Subject: Re: 2023/92452 173 Foyroyd Lane

PROPOSED PART GROUND FLOOR LAYOUT

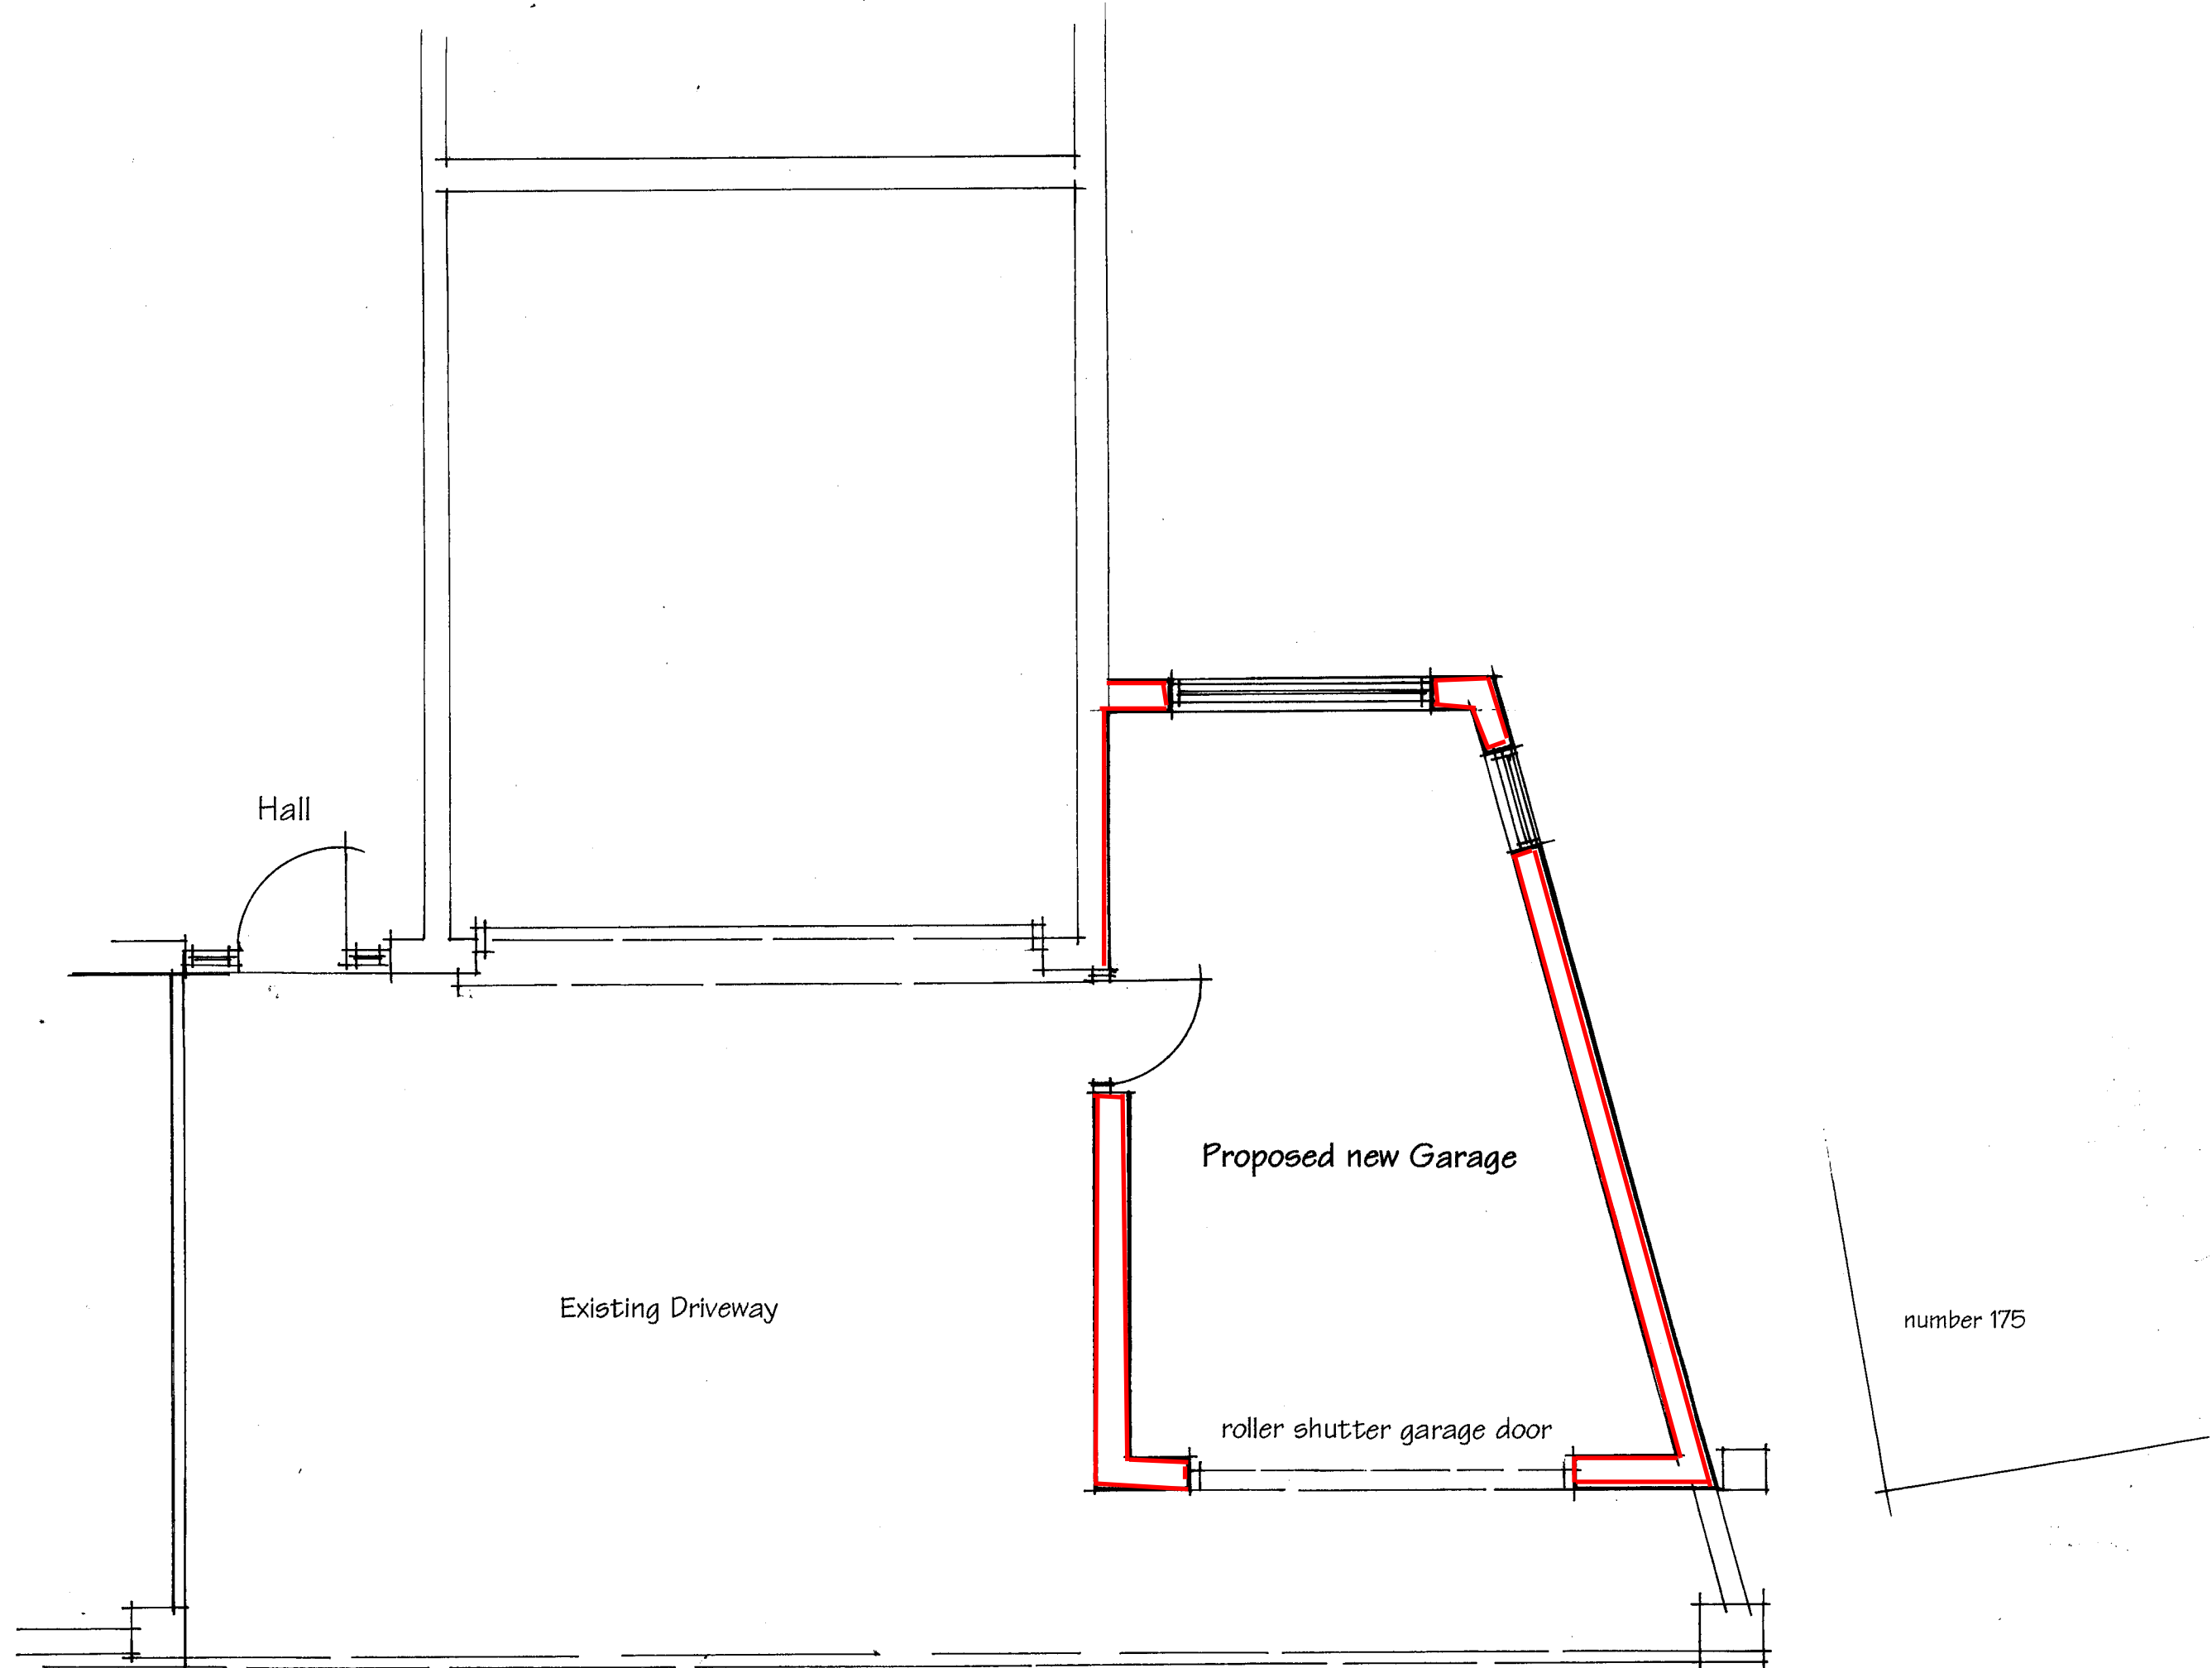
This application has been reviewed internally and is currently recommended for refusal for the following reasons:
The proposed garage by virtue of its design, scale and location would form an unsympathetic addition to the property and an incongruous feature within the street scene. To permit the proposal would be contrary to Policy LP24 of the Kirklees Local Plan, the House Extensions and Alterations SPD and advice contained within Chapter 12 of the National Planning Policy Framework.

PROPOSED PART FRONT ELEVATION

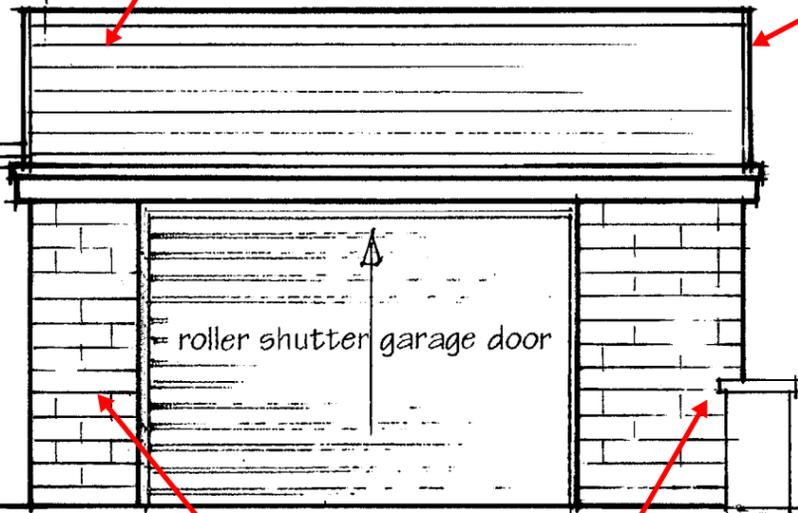
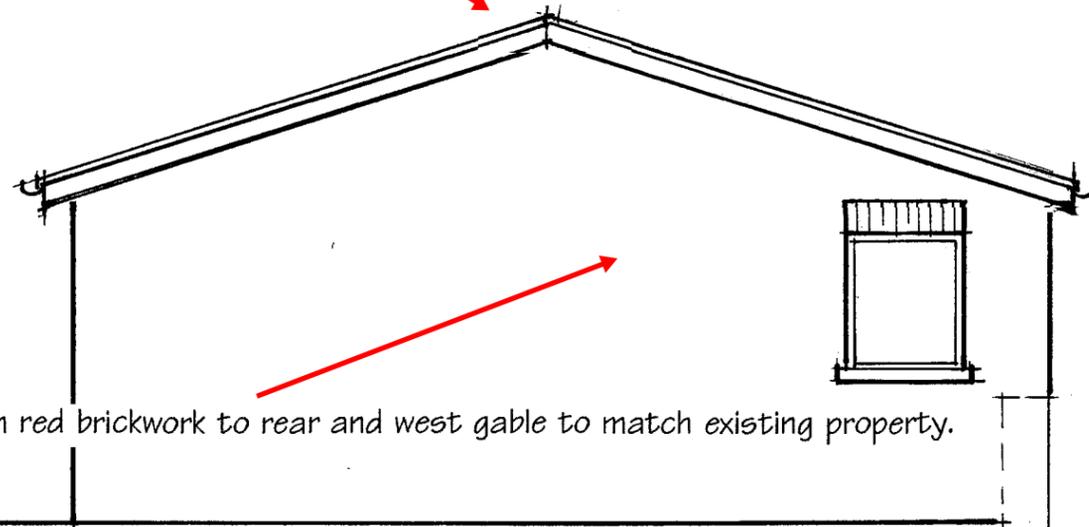
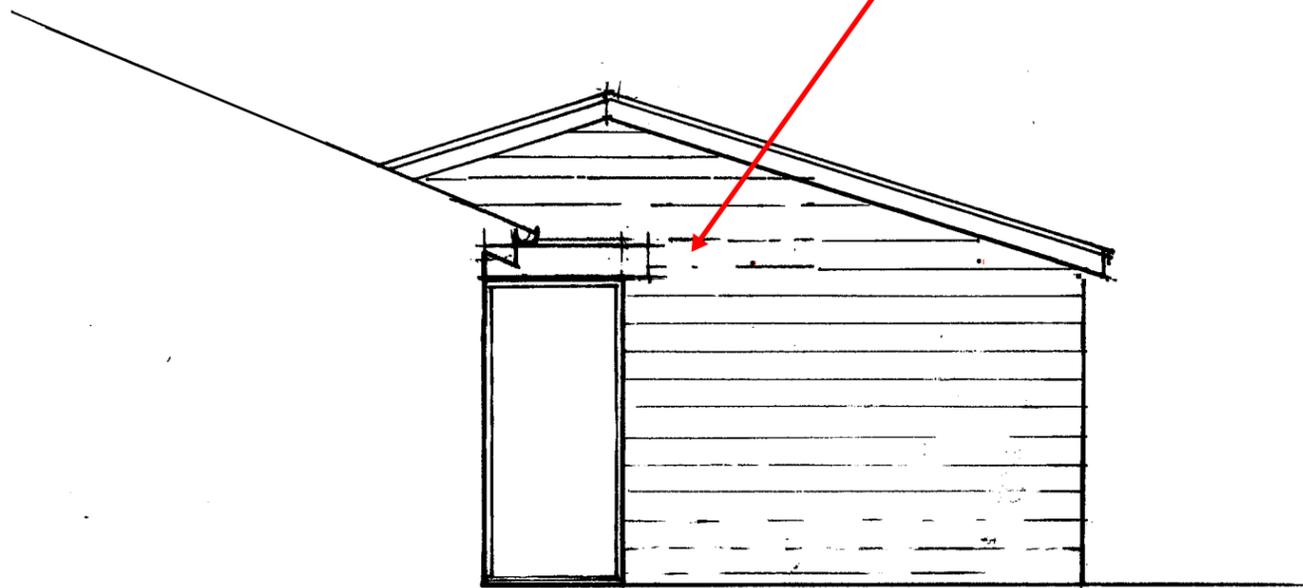
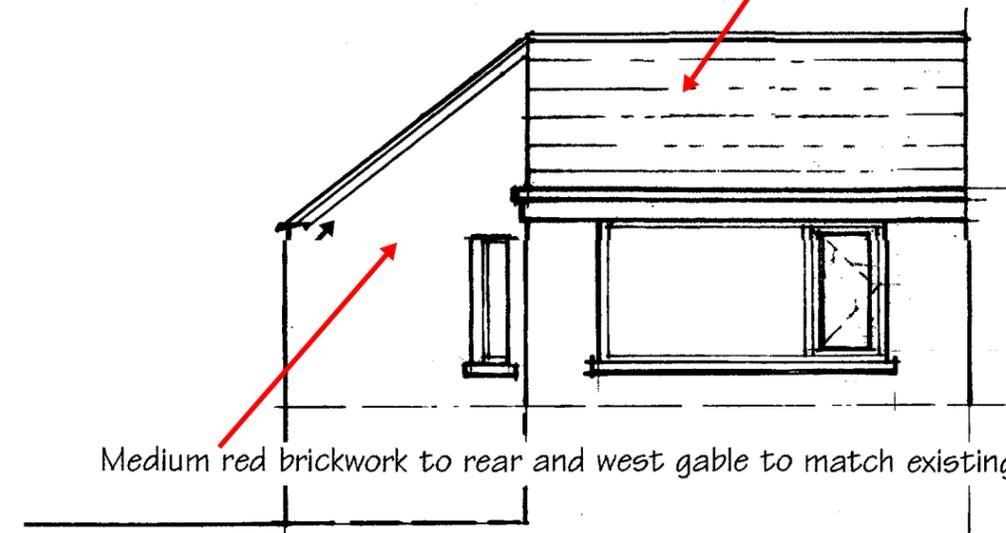
I had originally designed the higher-pitched roof to match the property that it was adjacent to, this did increase the bulk size of the garage. I am happy to lower the roof pitch so that the garage is less prominent, even a flat roof if that is your preference.

I have attached new plans with a lower roof pitch as above and hope that that is more acceptable to gain approval. Please get back to me if there are any other issues.
